From: Thomas Callaway
Sent: 11 September 2014 16:16
To: Planning.Responses
Subject: RE: Planning Consultation on: M/61/14/PL

Engineers comments in respect to surface water drainage:

APPLICATION NO: M/61/14/PL

Description of Works: Conversion of existing residence into 3 No new flats
(resubmission following M/13/14/)

Ground Floor / Site Plan 1:100

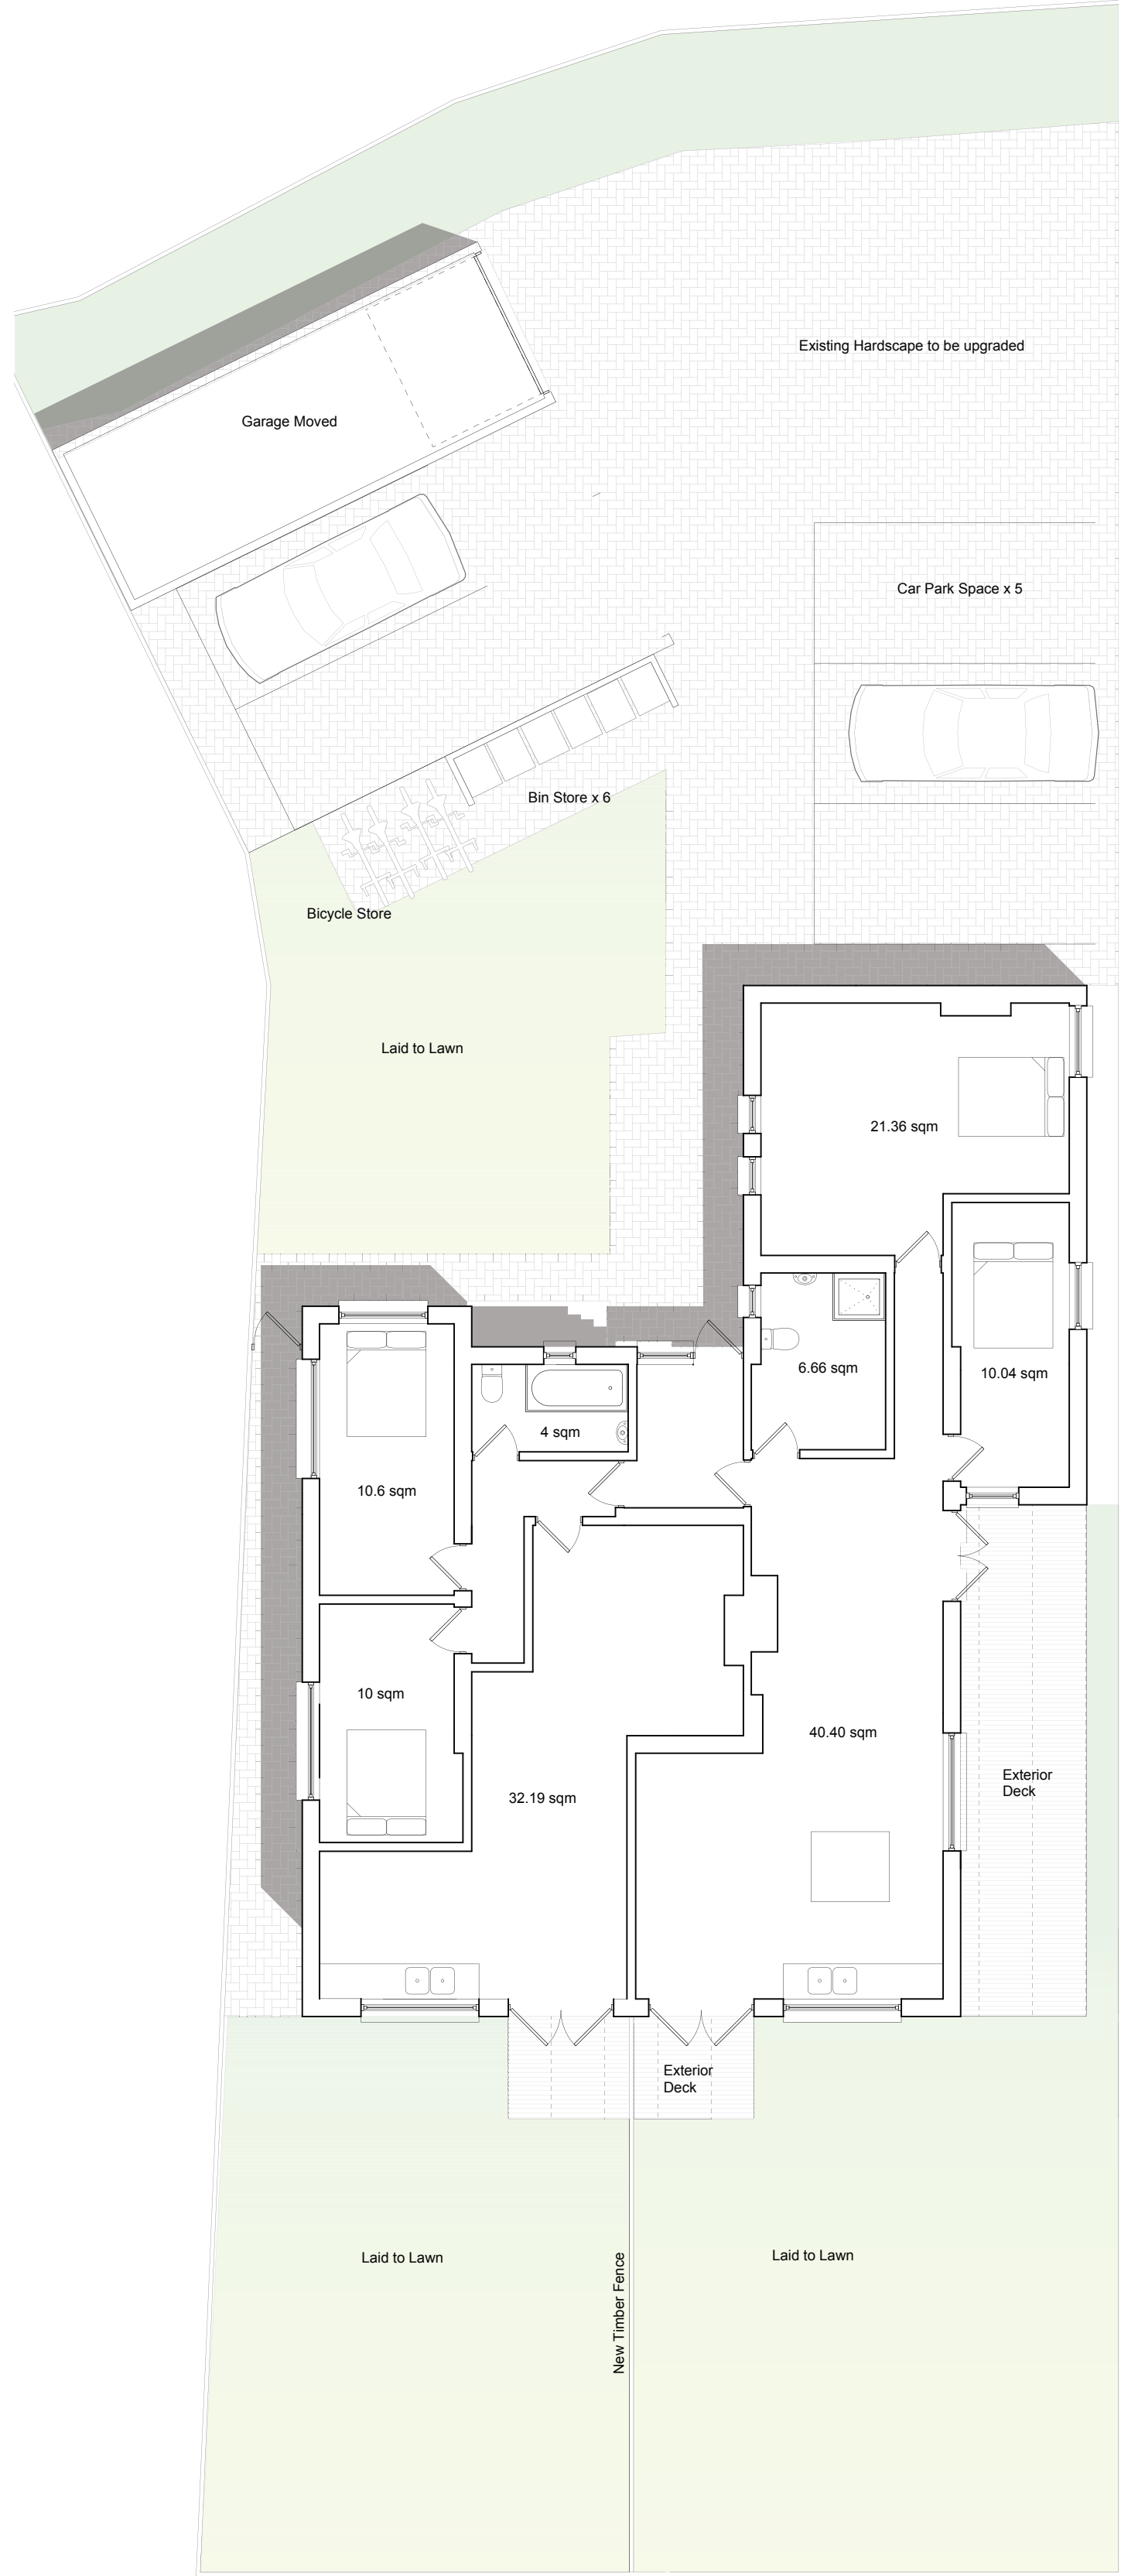
The ditch and garage should have a 3 metre easement between them to allow access for maintenance.
